2024/0685

Address: 11 Belle Green Gardens, Cudworth, Barnsley, S72 8EN

Description: First floor side and rear extension to 2 storey detached dwelling

Drawing Title **PROPOSED ELEVATIONS**

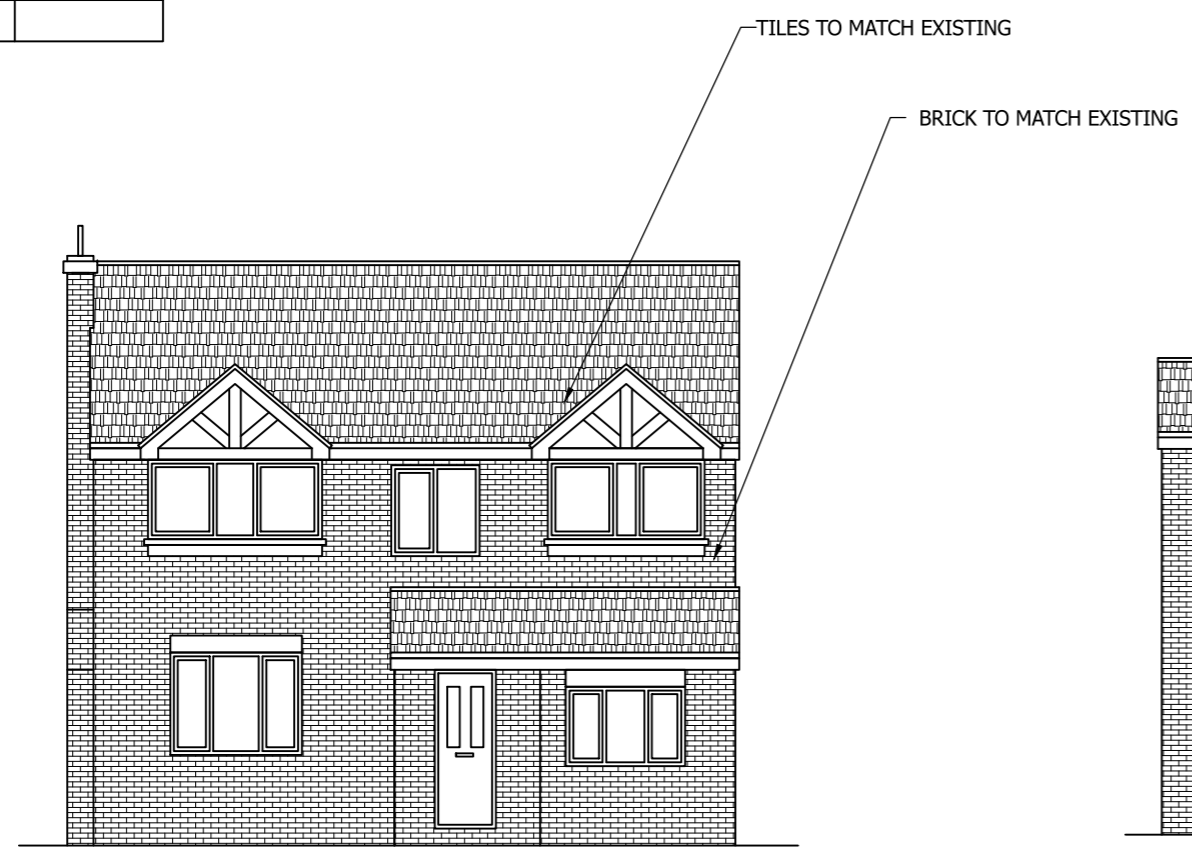
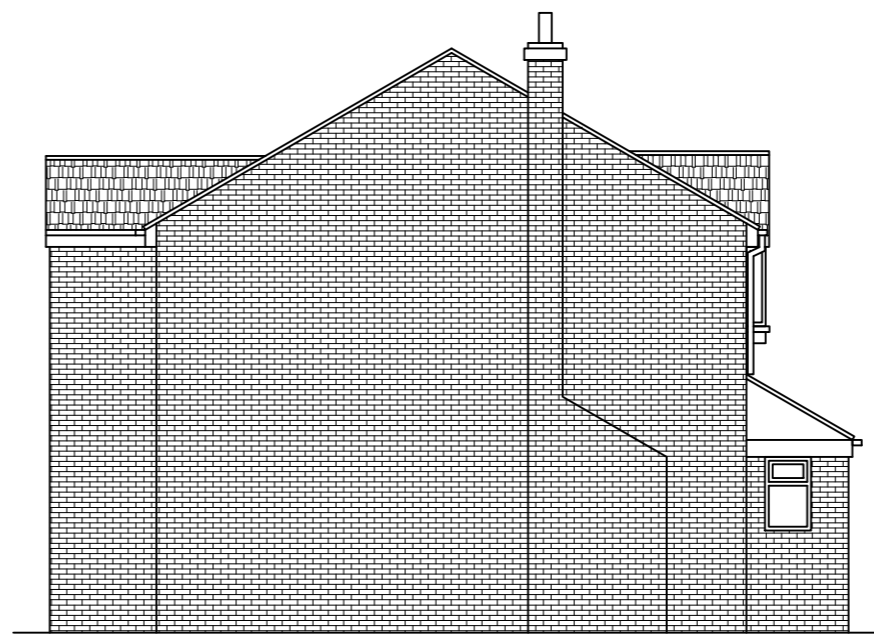
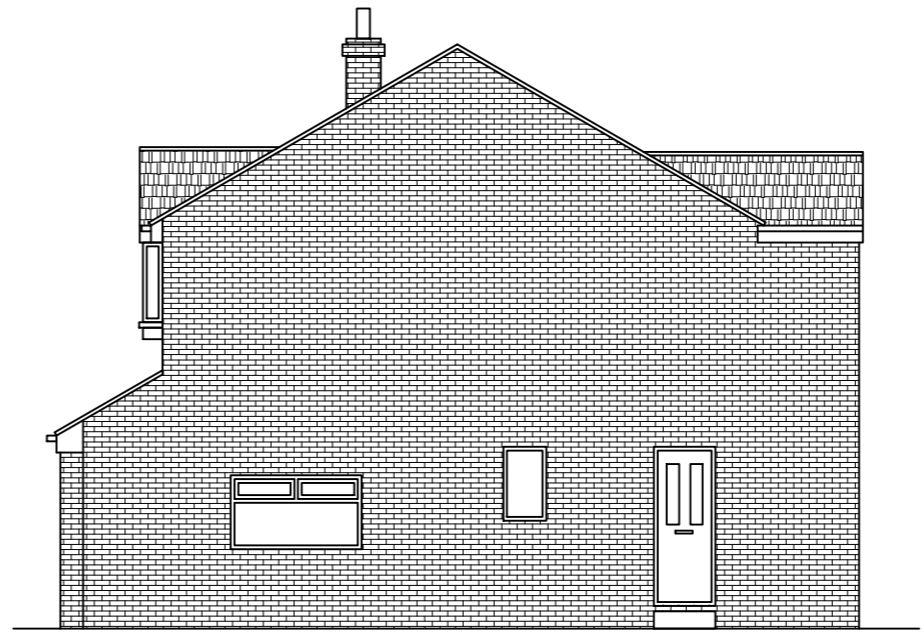
All existing roof and eaves heights have been checked on the existing plans and excluding the study (garage) roof and ground floor rear extension remain unaltered on the proposed plans.

- **Ground Floor Side Projection: 2.59m** (unchanged)
- **Ground Floor Length: 10.27m** (unchanged)
- **First Floor Side Projection: 2.59m**
- **First Floor Length: 9.21m** (excluding bay window, which matches original)
- **Maximum Eaves Height (dormer): 6.3m**
- **Maximum Roof height (dormer): 5.32m**

Ordinarily, a first floor set back and set down of the roof are required to show subordination to the original dwelling. On this occasion whilst a setback on the first floor has been partially achieved by including a matching bay window dormer, there is no set down of the roof. With no set down of the roof at either adjacent dwelling, it would not be prudent to request a set down of the roof, as this may impose a detrimental effect to the character of the dwelling and street scene, when the context of the three dwellings is considered together.
